**CITY OF ALBUQUERQUE  
PLANNING DEPARTMENT  
September 21, 2005  
DRB Comments**

**Project # 1004413**

**RE: Alvarado Gardens, unit 2/sketch**

DEVELOPMENT REVIEW BOARD--SPEED MEMO

**PLAT OF
 LOTS 43-A, 43-B, 43-C & 43-D
 ALVARADO GARDENS, UNIT No. 2
 SECTION 1, T. 10 N., R. 2 E., N.M.P.M.
 CITY OF ALBUQUERQUE
 BERNALILLO COUNTY, NEW MEXICO
 JULY, 2005
 SHEET 2 OF 2**

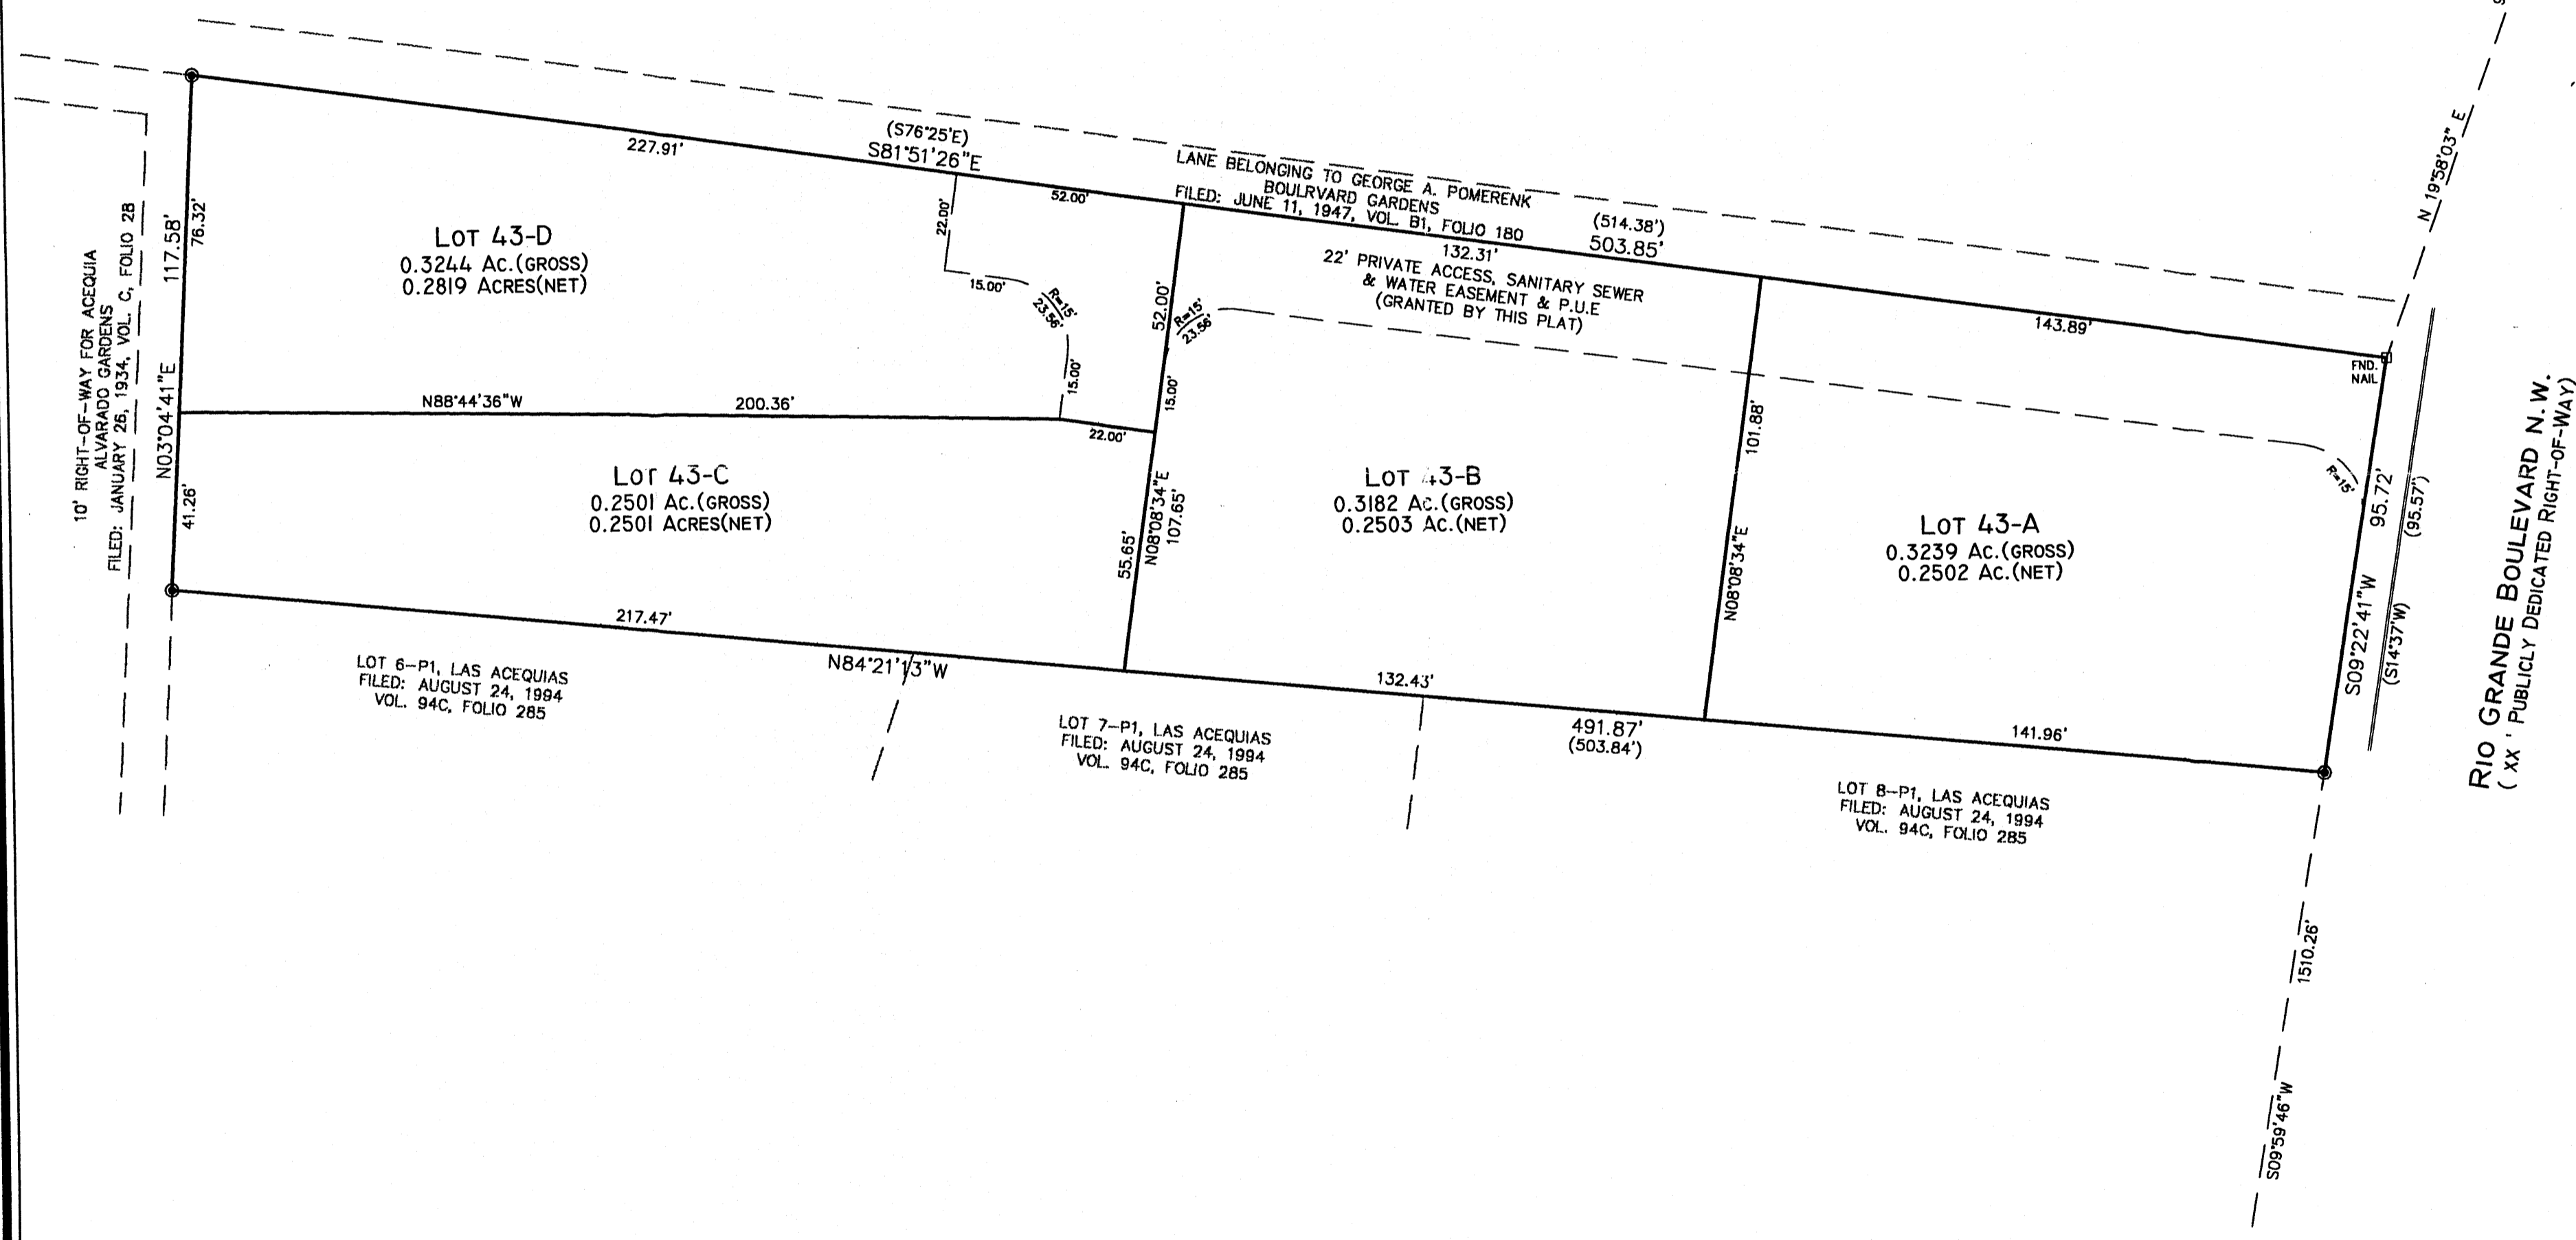
Lot 43-D does not have the required lot width per the RA-2 zone.

Lot 43-C does not have the required lot width per the RA-2 zone.

1. Must request a Water/Sewer Availability Statement prior to Preliminary Plat approval.
2. For a 4 lot subdivision, public water/sewer line extensions will be required. Minimum public easement width will be 25, with a separate 10' wide PUE for a total easement encumbrance of 35'.
3. A 3 lot subdivision would allow private water/sewer service lines within the private easement as shown.
